M3 Junction 9 Unique Reference: 20036783

Application by National Highways for an Order Granting Development Consent for the M3, Junction 9 Improvement

Submission

Winchester Action on the Climate Crisis

Contains OS data © Crown Copyright and database right 2020

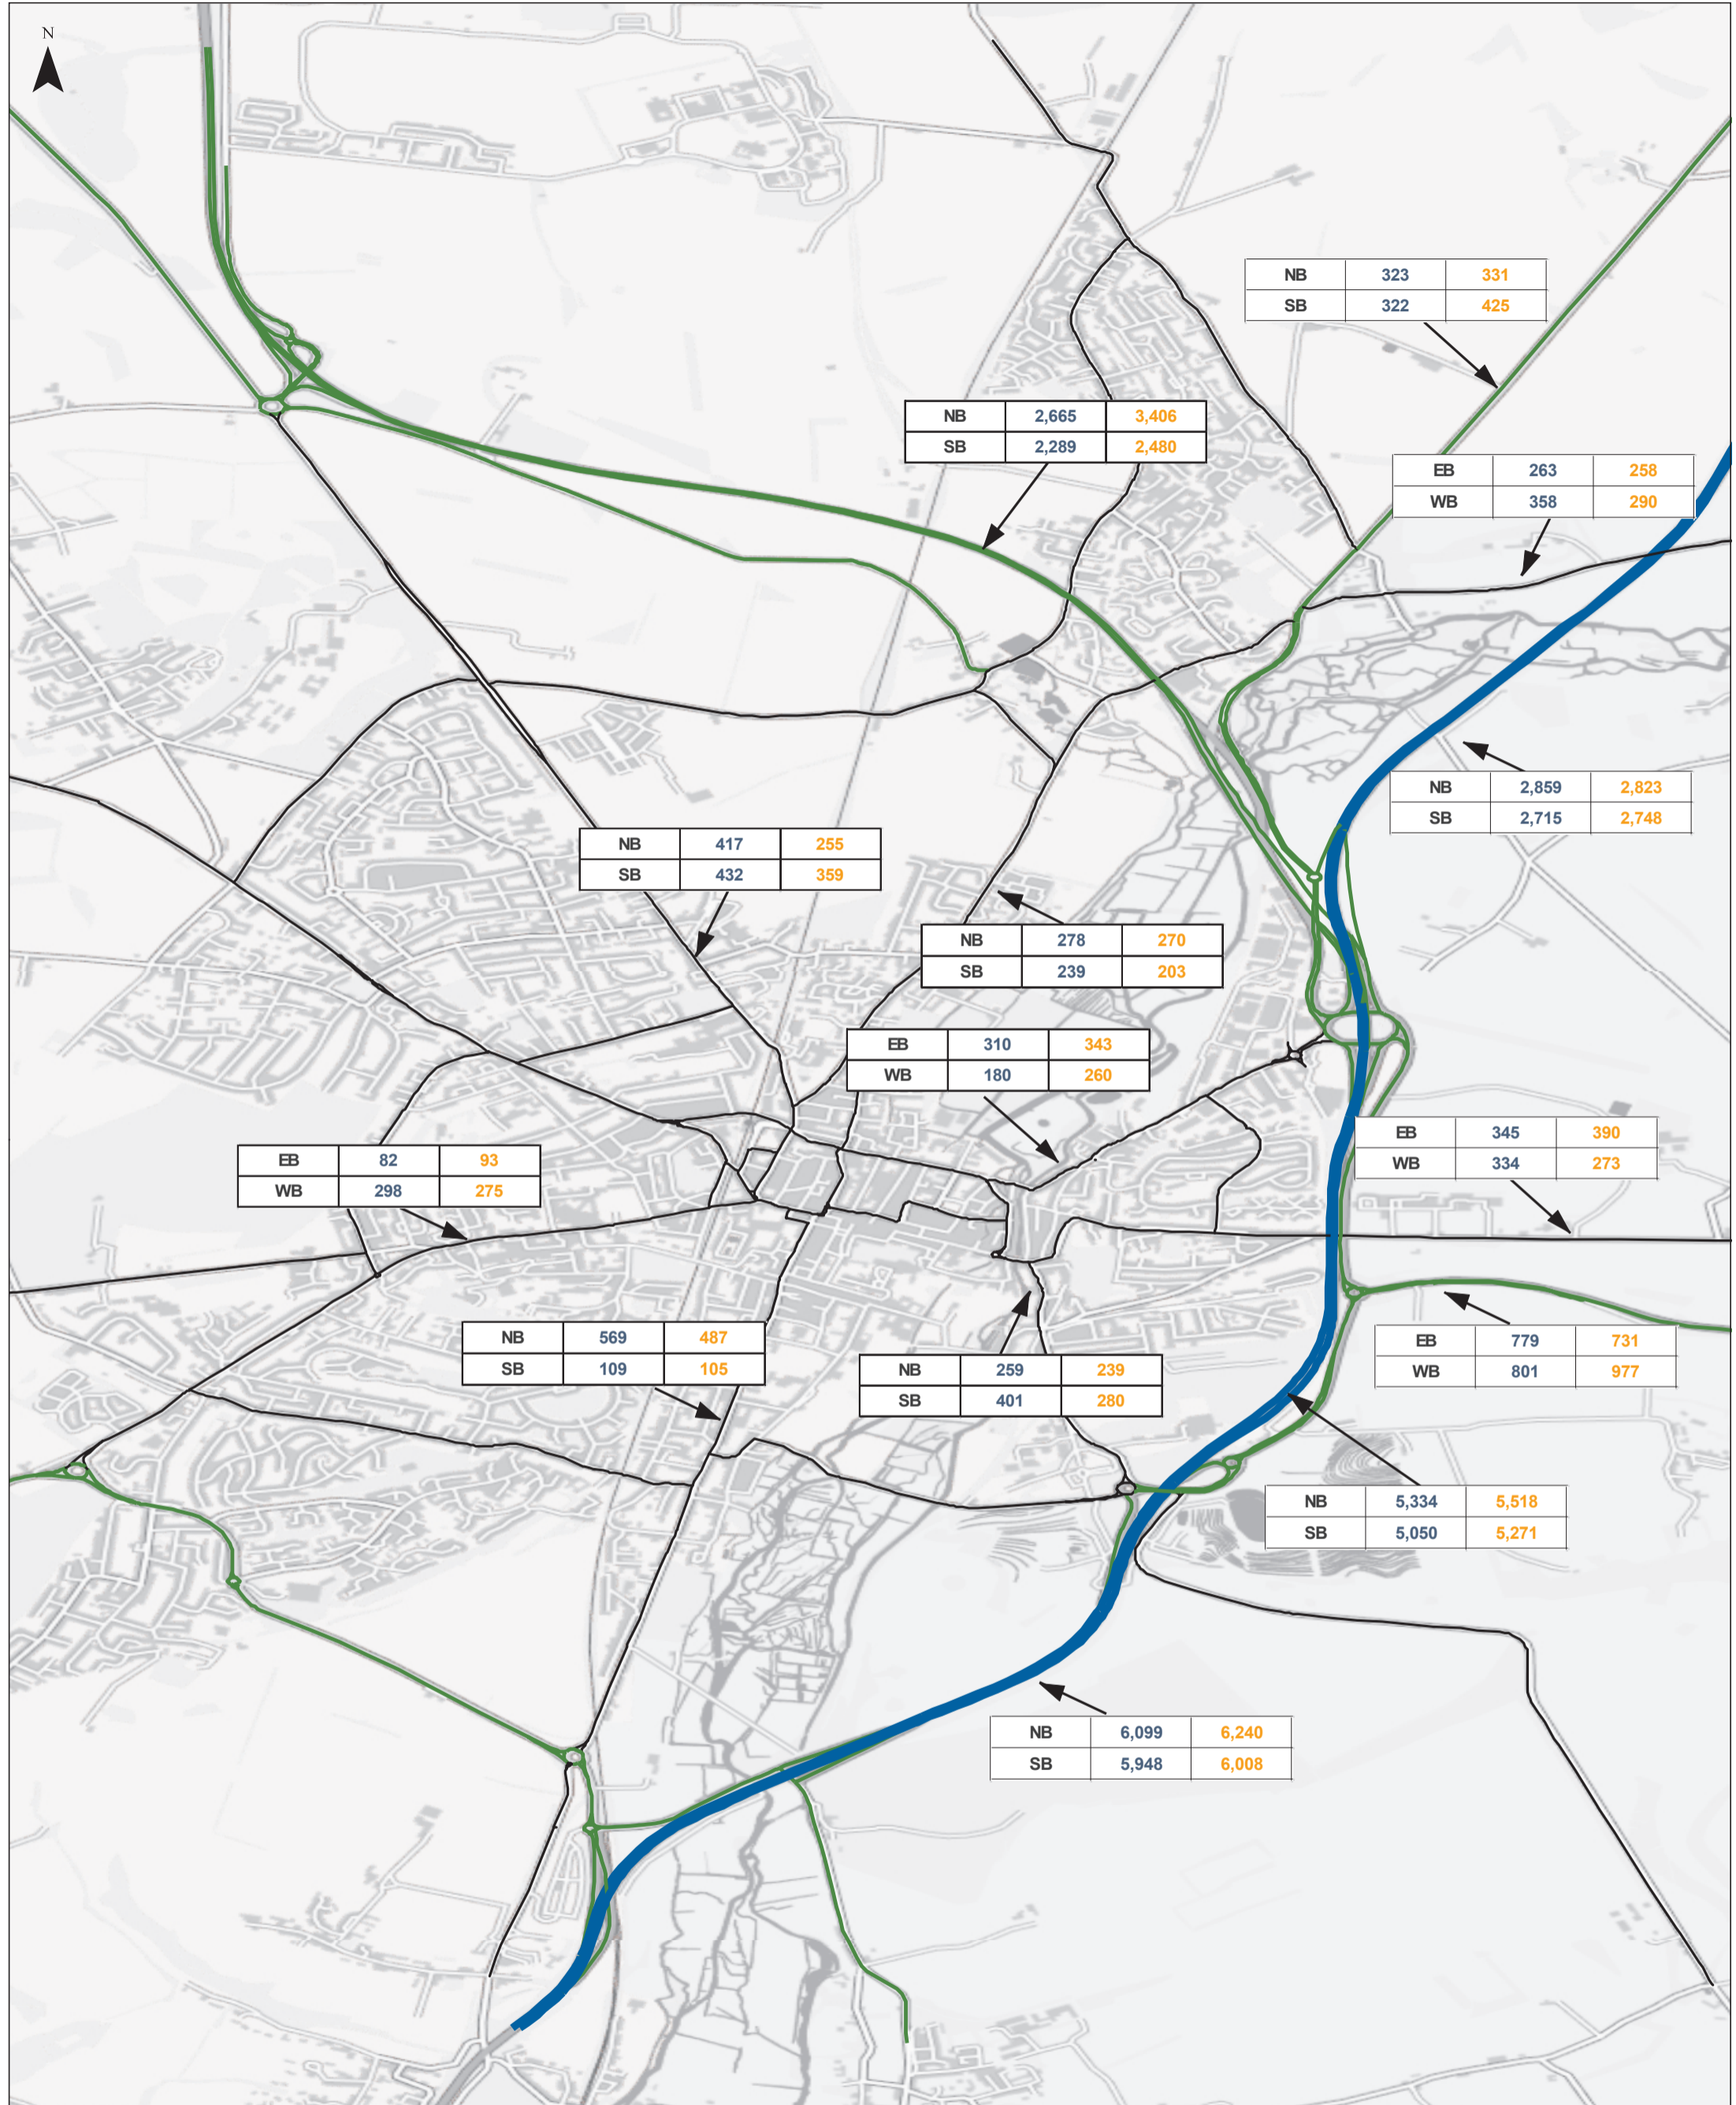
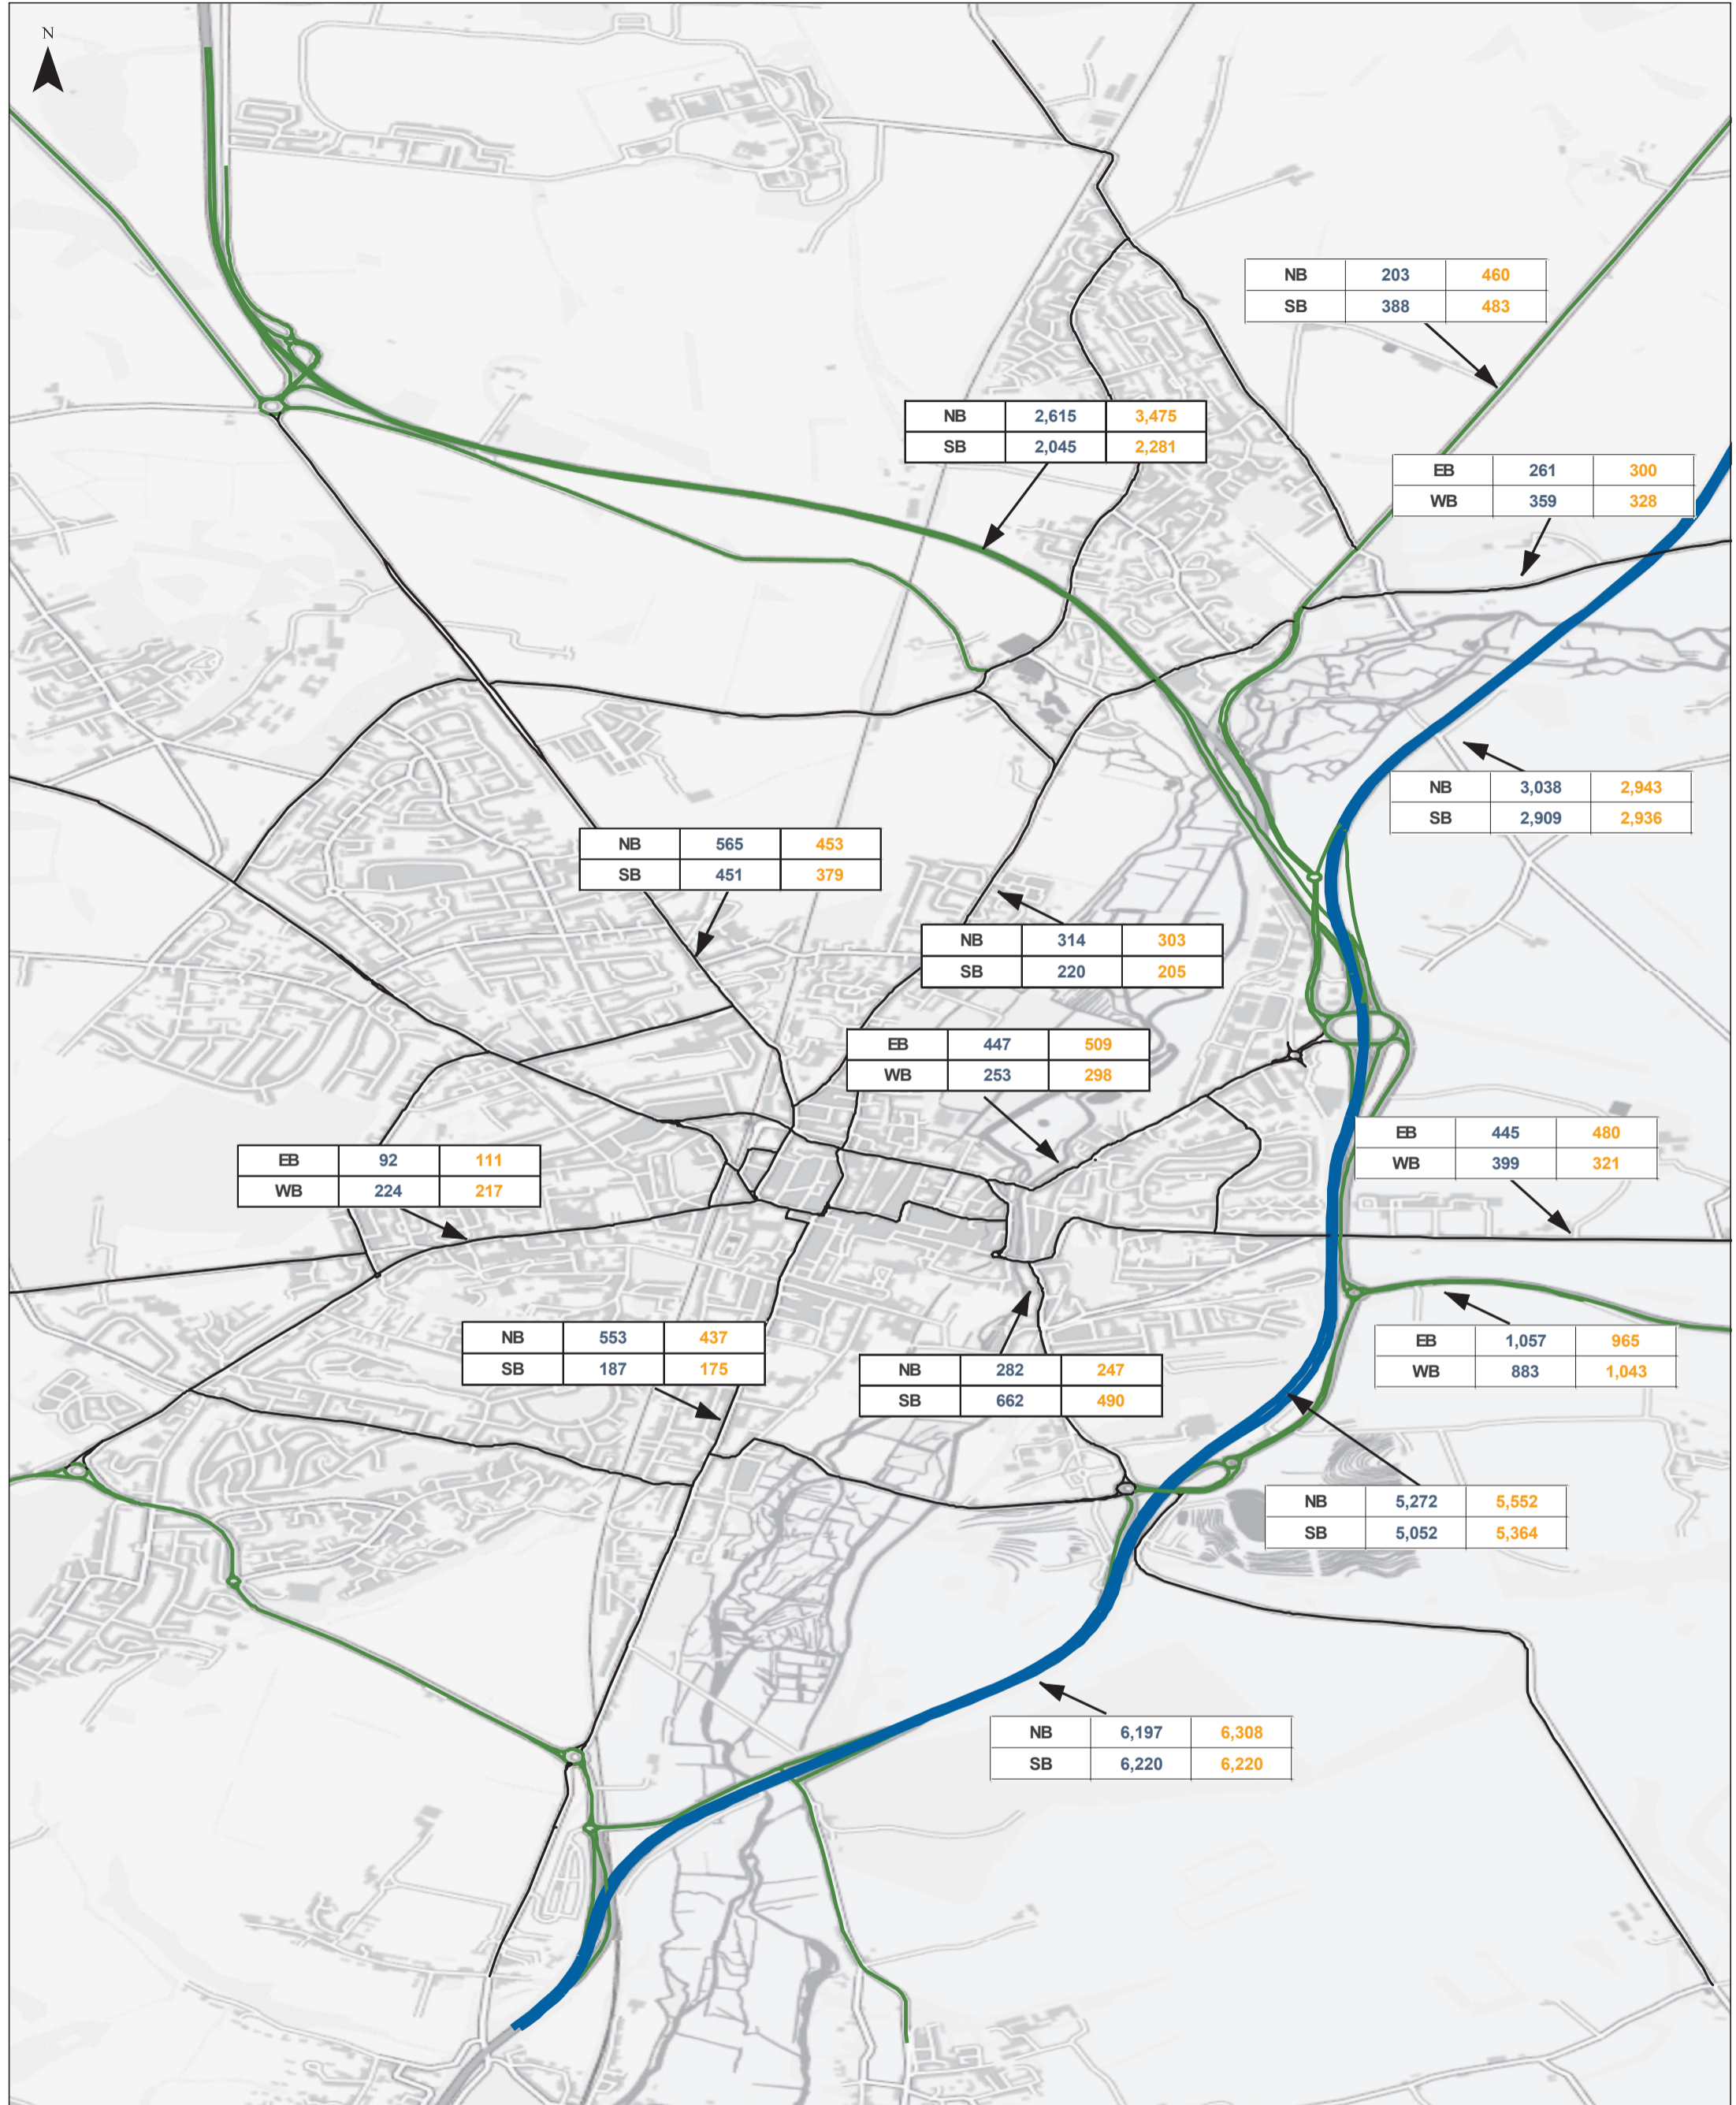
The modelling maps in document [7.10 Combined Modelling and Appraisal Report](#) compare traffic flow if the project does not go ahead (Do Minimum (DM)) with what will happen if the project goes ahead (Do Something (DS)). The final comparison models what will happen in 2047.

In the table below we have added together both directions for the AM peak, the period between the peaks, and the PM peak.

2017	AM+IP+PM		DS/DM%
	Do Minimum	Do Something	
Andover Road	2,843	2,374	83.50%
Romsey Road	1,077	1,092	101.39%
St Cross Rd	2,028	1,779	87.72%
Chesil Str	2,371	1,873	79.00%
Alresford Rd	2,561	2,501	97.66%
Easton Lane	1,712	2,152	125.70%
Worthy Rd	1,640	1,503	91.65%
Petersfield Road	5,392	5,735	106.36%
Local Roads Totals	19,624	19,009	97%
A34N	14,810	17,595	118.80%
A33N	1,986	2,183	109.92%
M3N	17,308	17,260	99.72%
M3 Sports Centre	31,704	32,689	103.11%
M3 Twyford Down	37,455	37,670	100.57%
Strategic Roads Totals	103,263	107,397	104.00%
Full total	122,887	126,406	102.86%

There are some roads that will suffer major traffic increases: especially Easton Lane, and the A34 as it passes through King's Worthy. Some roads will benefit from major decreases such as Chesil Street and Andover Road.

However the overall picture is one of very little change. It is very surprising that the modellers predict a small reduction in traffic along the M3 from Winchester to Basingstoke. It will reduce traffic levels within Winchester Town very little.

The report above accepts that induced demand is a significant phenomenon. In the worst cases, especially where there is traffic congestion, traffic will increase to fill the available space. The applicant proposes doubling (at least) the carriageway width on the route through the junction linking M3S and A34N in both directions. In a situation like this it would not be unknown for traffic to double. This route does show the greatest two-way traffic increase across the 20 year modelling period but the increase of 26% predicted by the modelling understates the likely results of a 100% capacity increase:
